SUBJECT: SFD2308-0134
SINGLE FAMILY DWELLING

Here are the results of all Inspections located at **118 RETREAT DR:**

SOUTH
B326-A
RFP-1
 BLAKESTONE
 RALEIGH

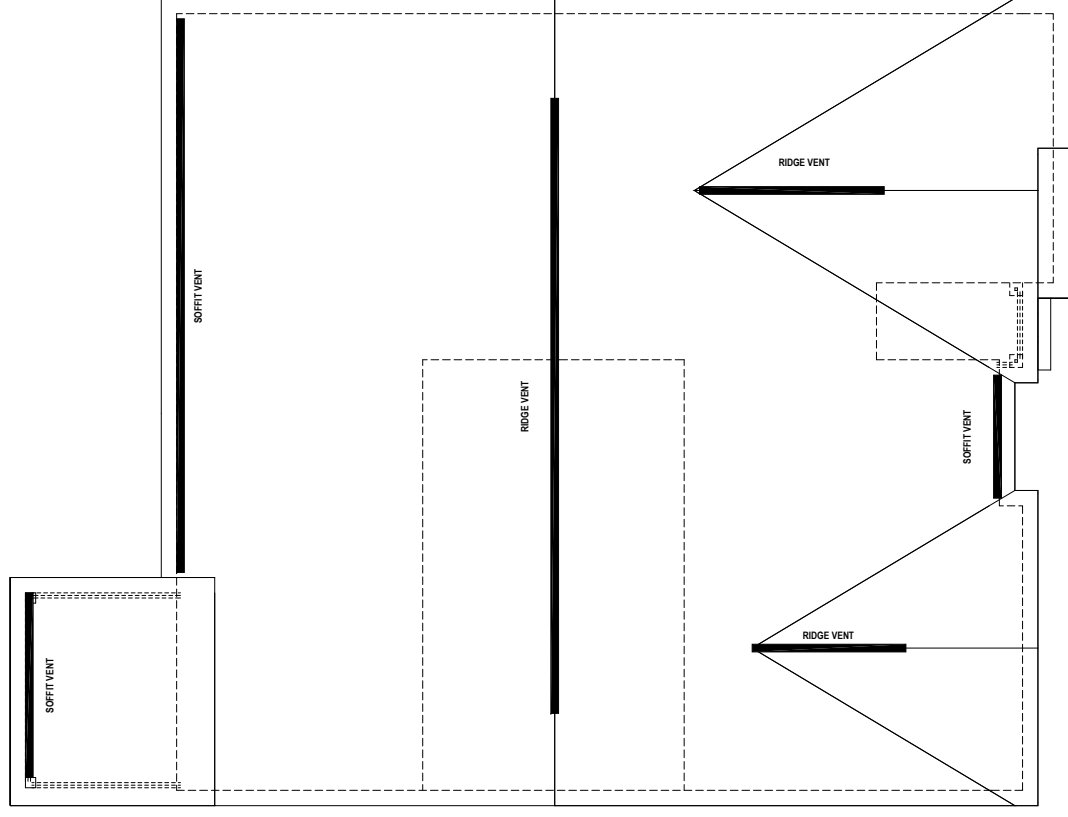
1. 2-2x6 header at garage man door. 2. Hurricane clip for b1ge truss located between girder and front right window. 3. Air block around hvac duct above upstairs shower/tub. 4. Missing 2 through bolts in A4GR truss above family room. 5. H1ge truss gusset damaged at joint 16. Located to right of rear door over porch beam column. Ok to insulate

SOUTH
B326-A
FS-1
 BLAKESTONE
 RALEIGH

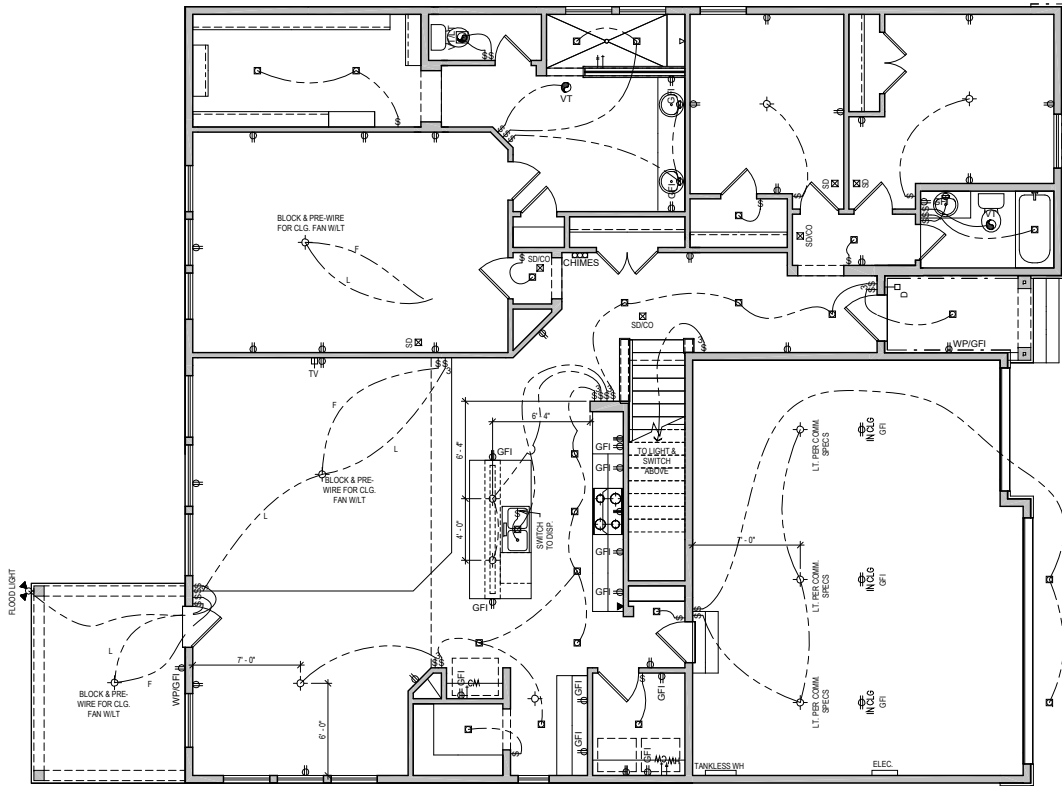
no covered porch on foundation survey
